**Re: American Gypsum
4600 Paseo Del Norte
Traffic Circulation Layout
Architect's Stamp 03-27-17 (D17-D076)**

Based upon the information provided in your submittal received 03-27-17, the above referenced plan cannot be approved for Building Permit until the following comments are addressed:

**B1** ENLARGED SITE PLAN  
1"=100'-0"

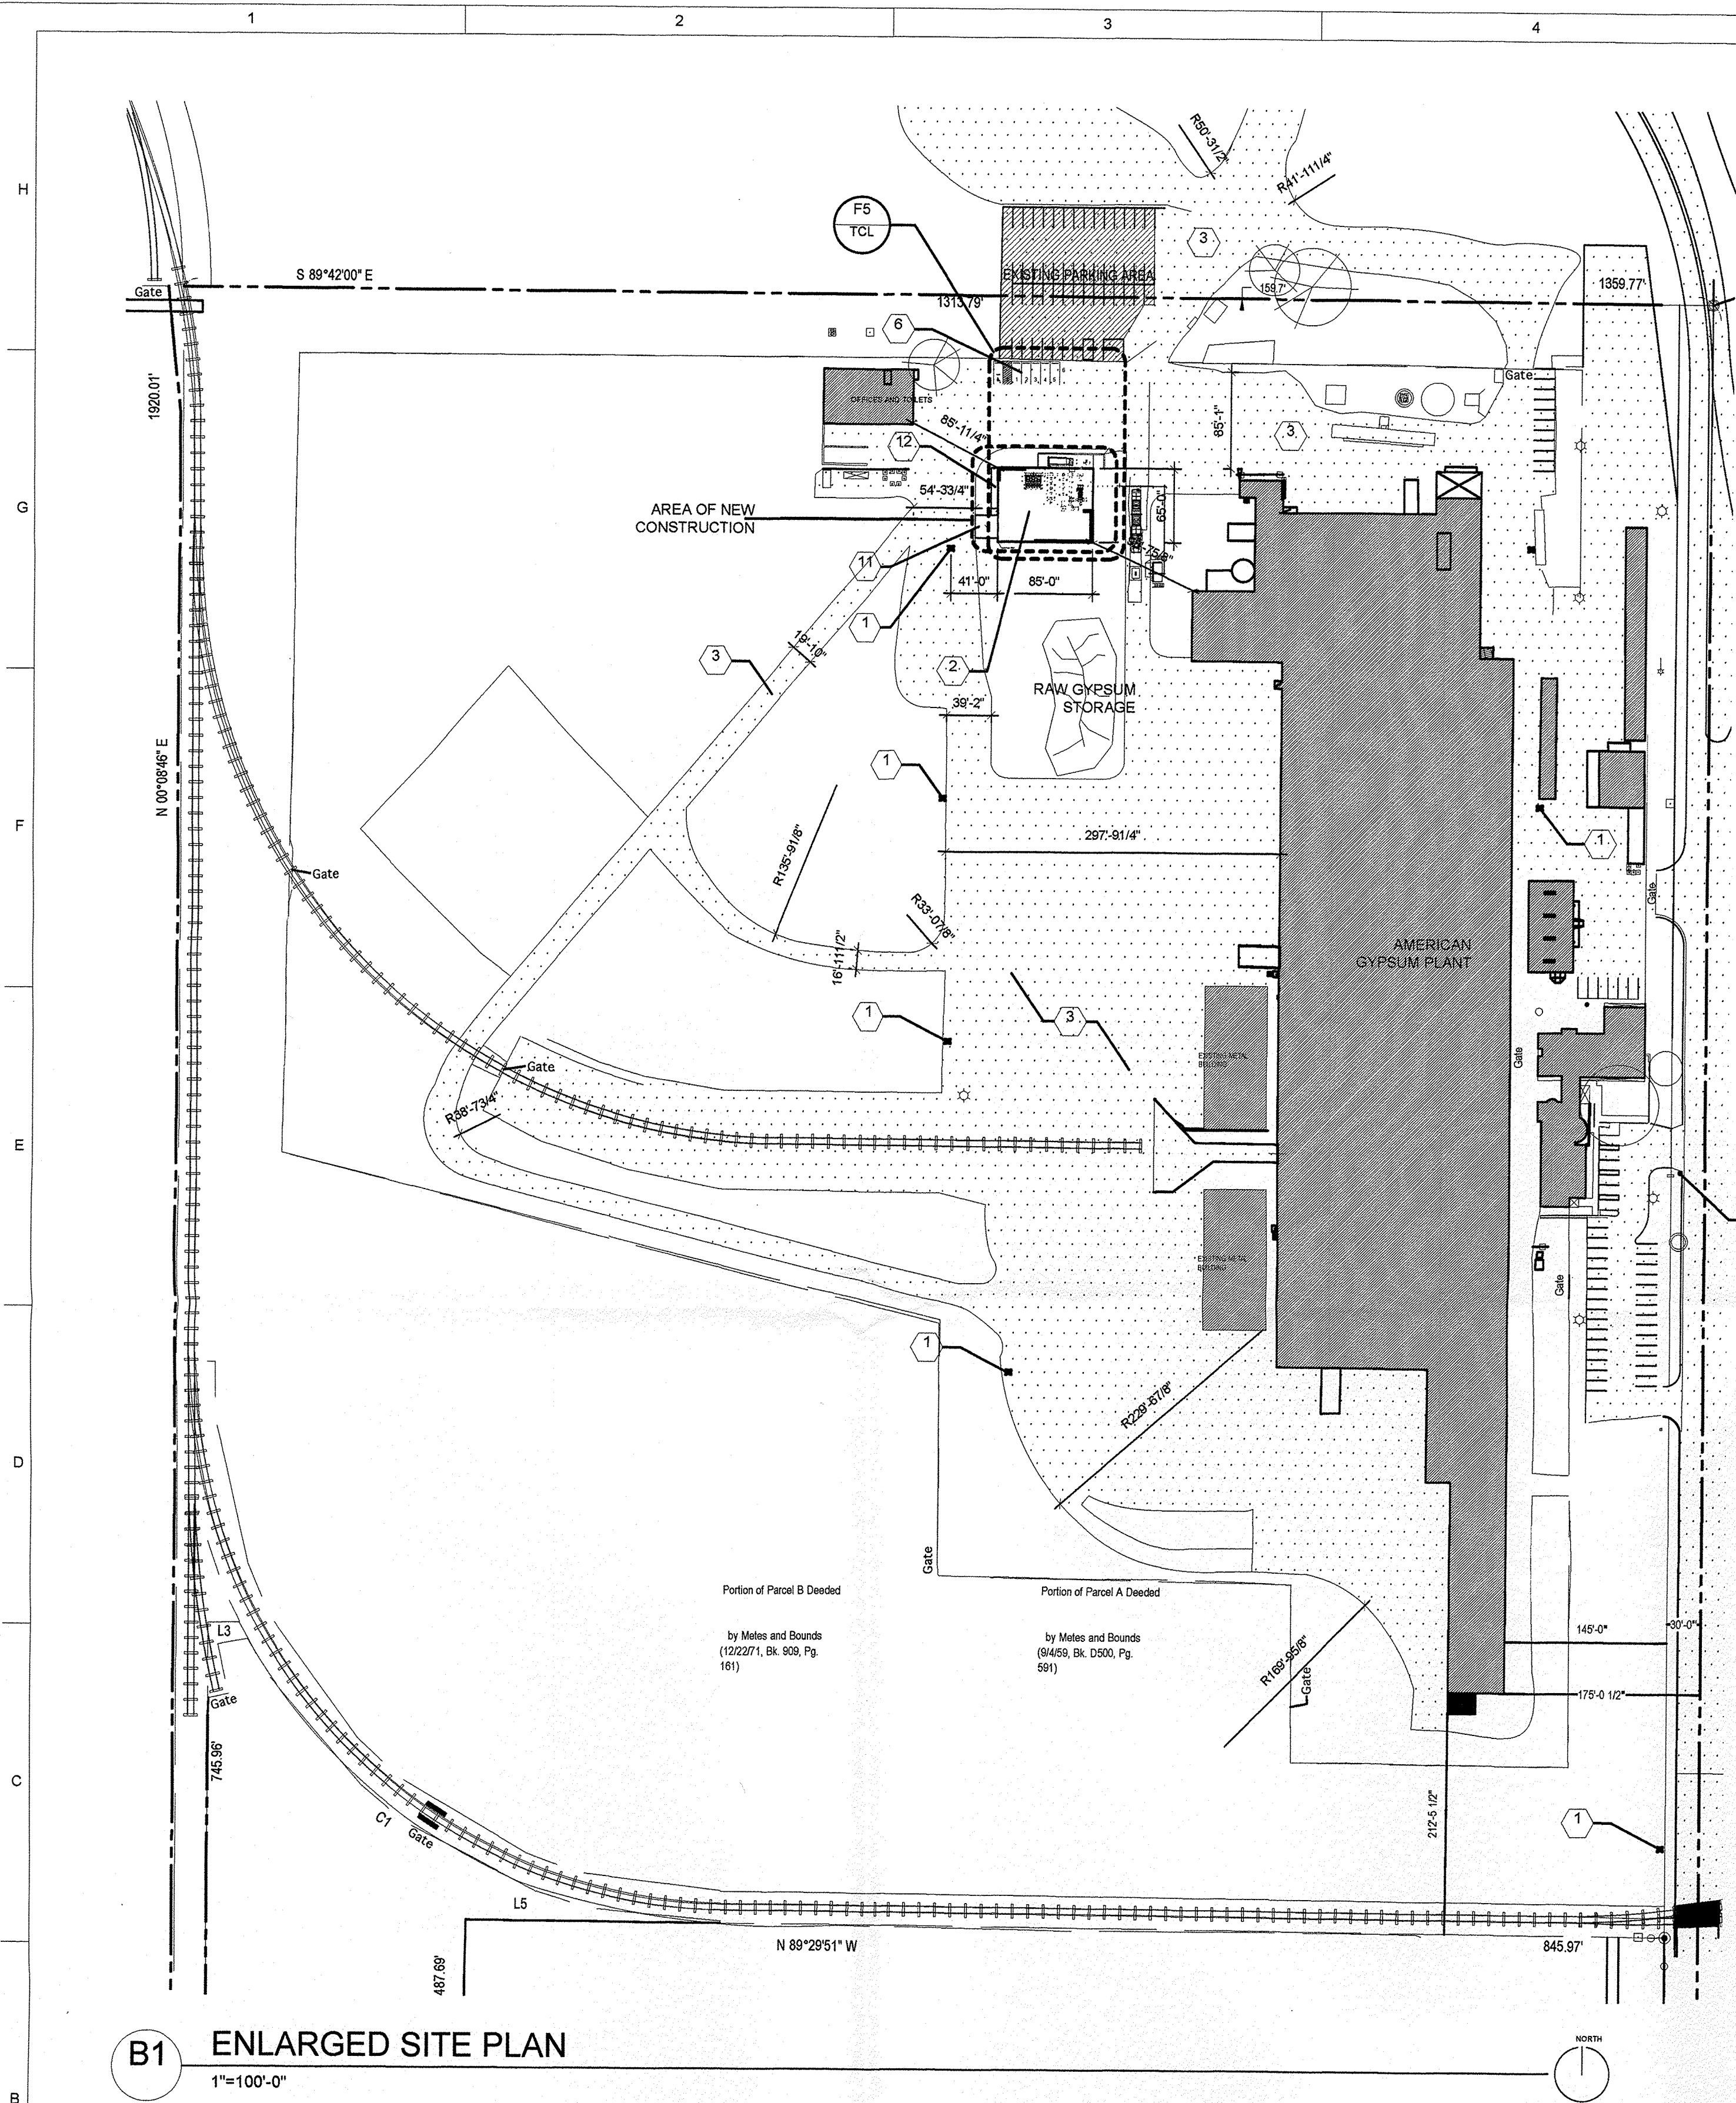
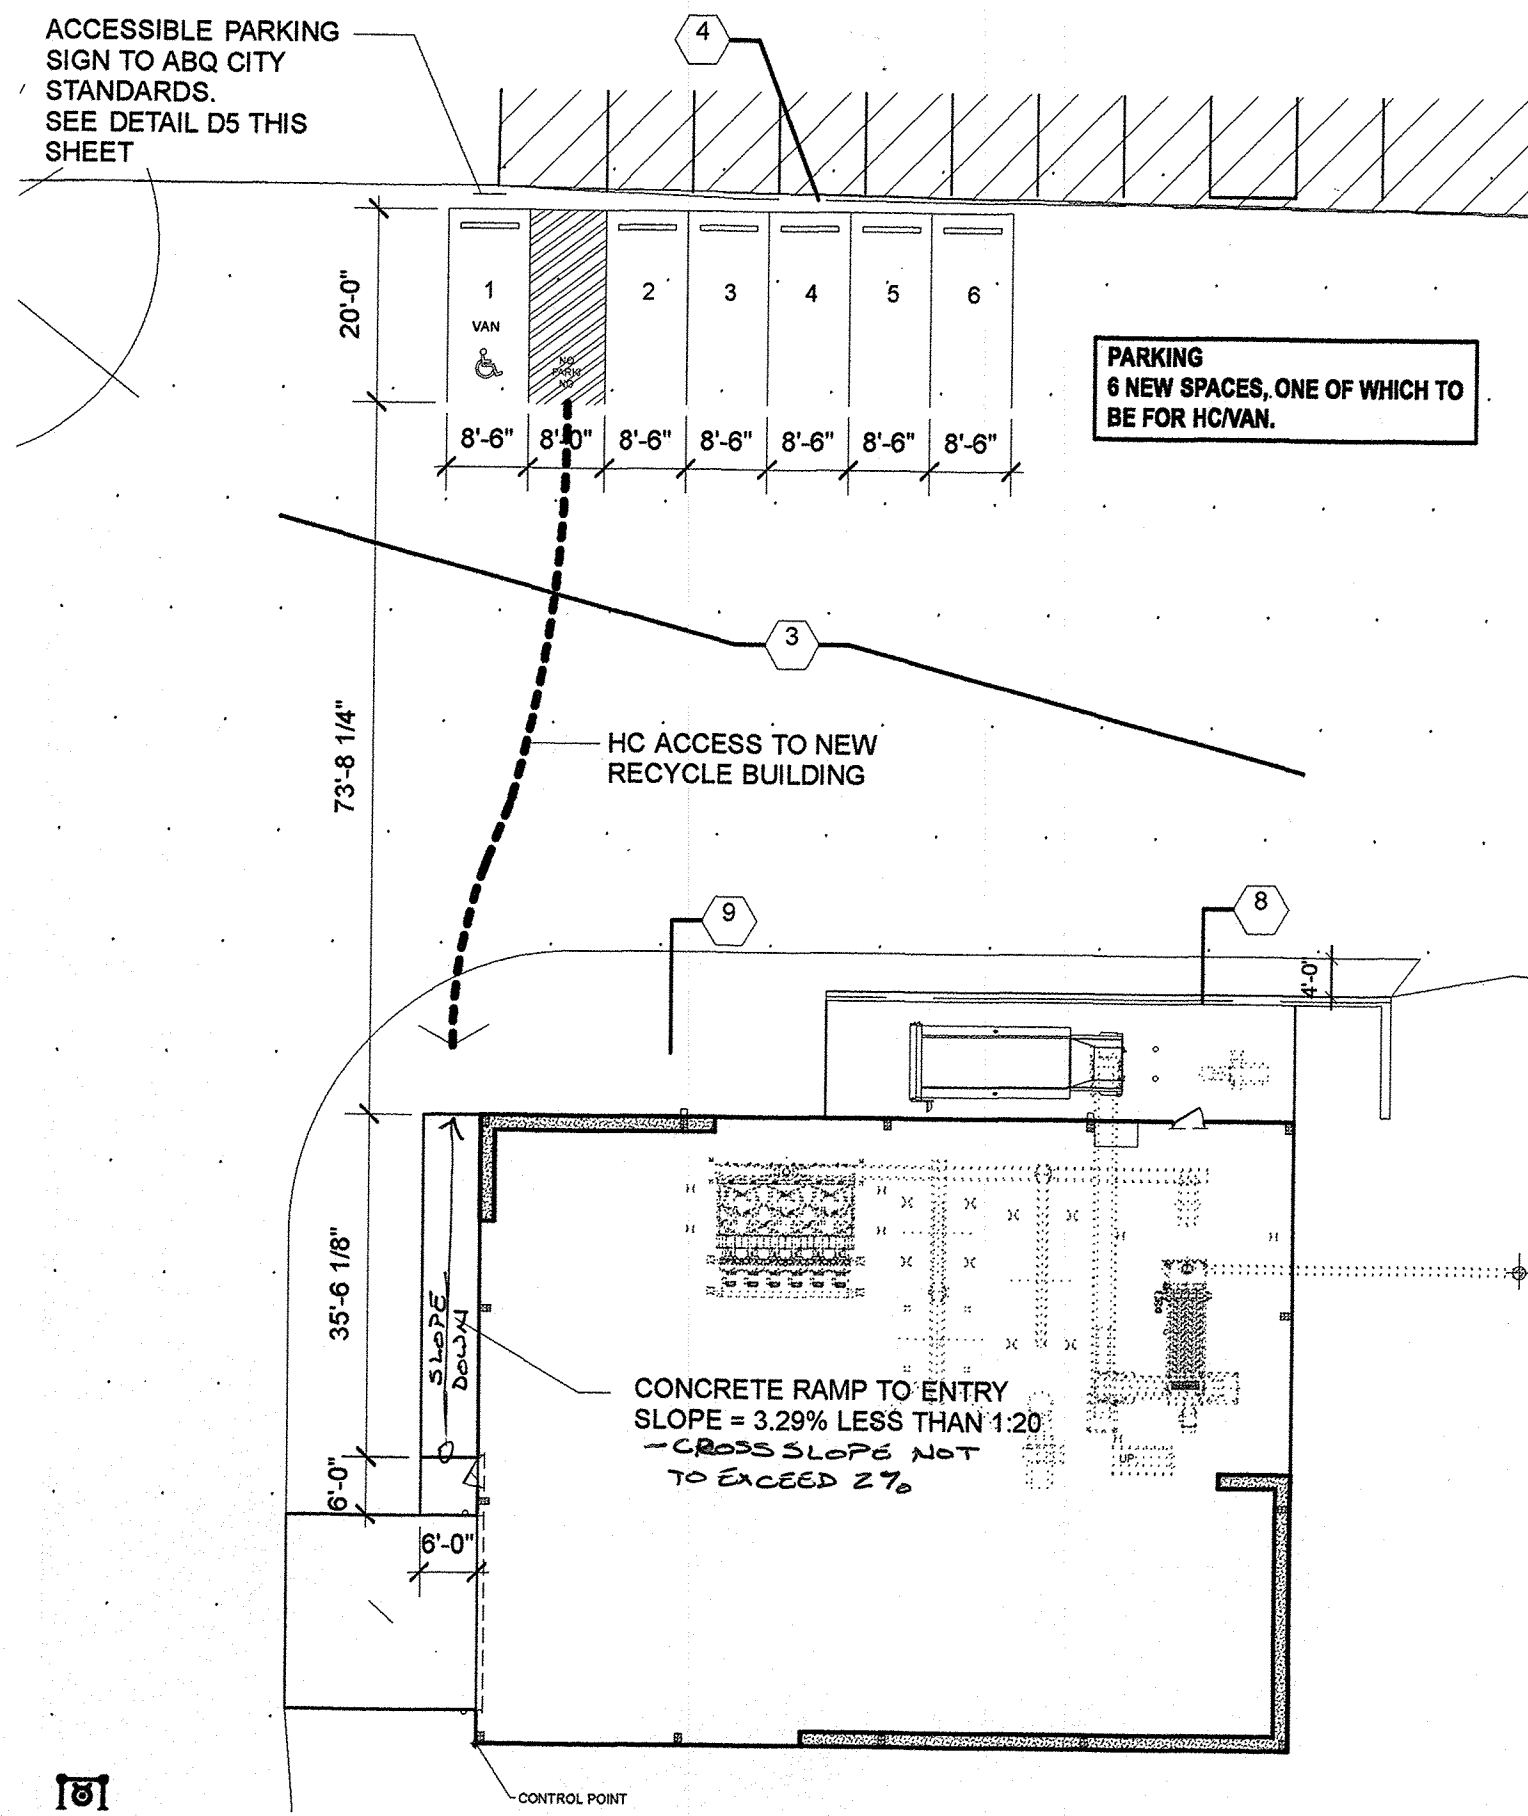
1. Please provide detail of the new building/construction for the TCL. I am not able to determine if the ramp is ADA compatible and how the new concrete apron will work with the site.
2. Per DPM, a 6 ft. wide ADA accessible pedestrian pathway is required from the HC parking stall access aisles to the building entrances. Please clearly show this pathway and provide details.
3. ADA accessible pedestrian pathway should not be placed behind parking space or adjacent to a vehicular way. Vehicle and pedestrian/wheel chair conflicts should be avoided as much as possible.
